THE VICTORIAN SOCIETY

Your reference: 2023/62/90024/W

RE: Partial demolition of Listed Building to facilitate refurbishment and extension of the George Hotel to form 90+ room C1 hotel with associated ancillary uses (including bar, restaurant, gym, conference room) (within a Conservation Area)

Sheet Name: Level -01 Demolition

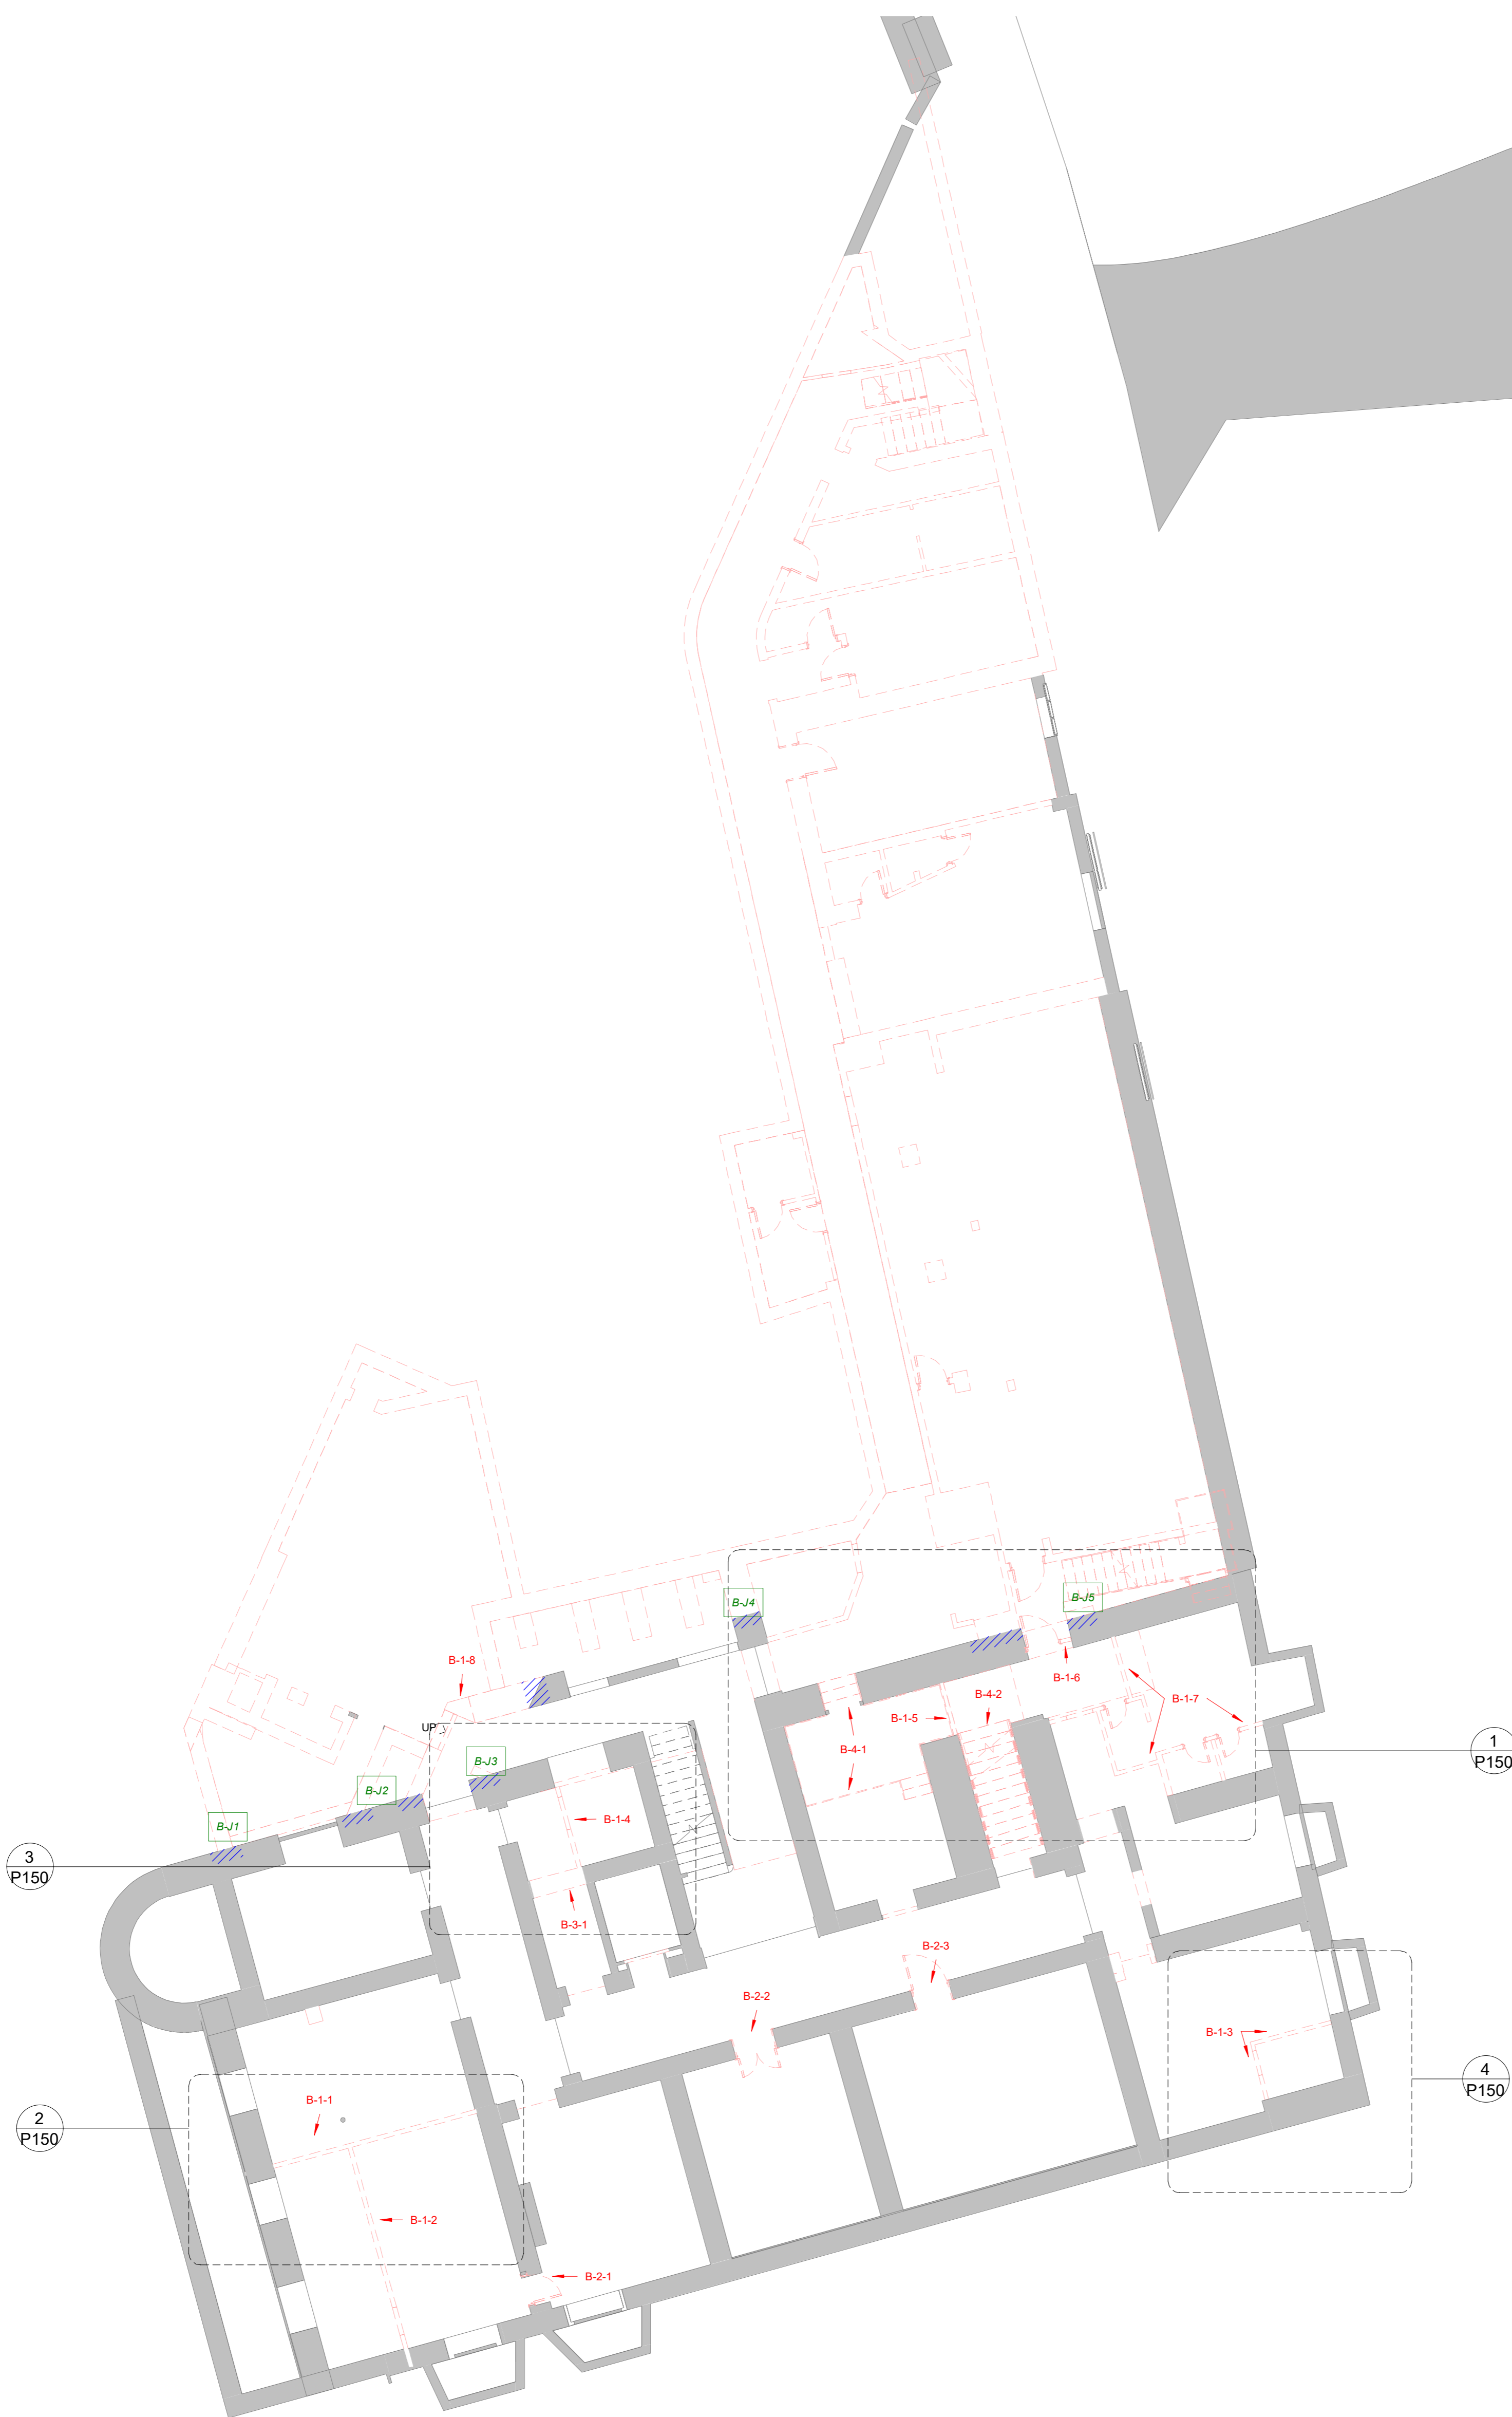
The East wing, facing onto John Williams Street, was constructed in 1874 and contained a large dining room, billiards room and bedrooms above. The exterior seamlessly extends the Italianate classical design of the main building. The interior, although altered, contains features such as cornicing and skirting and a coherent 19th century hotel plan form, in particular the dining room. The proposal entails the almost complete demolition of this wing with only the John Williams Street façade retained.

The loss of the interiors would cause substantial harm to the significance of this heritage asset. The coherent hotel plan form, as noted in the listing description, would be fragmented and C19 decorative joinery lost. This wing was retained in Historic England's 2022 update of the listing and is therefore considered to be of special architectural and historic interest. Again, the 1874 aspects of this wing could be retained and incorporated into a new scheme.
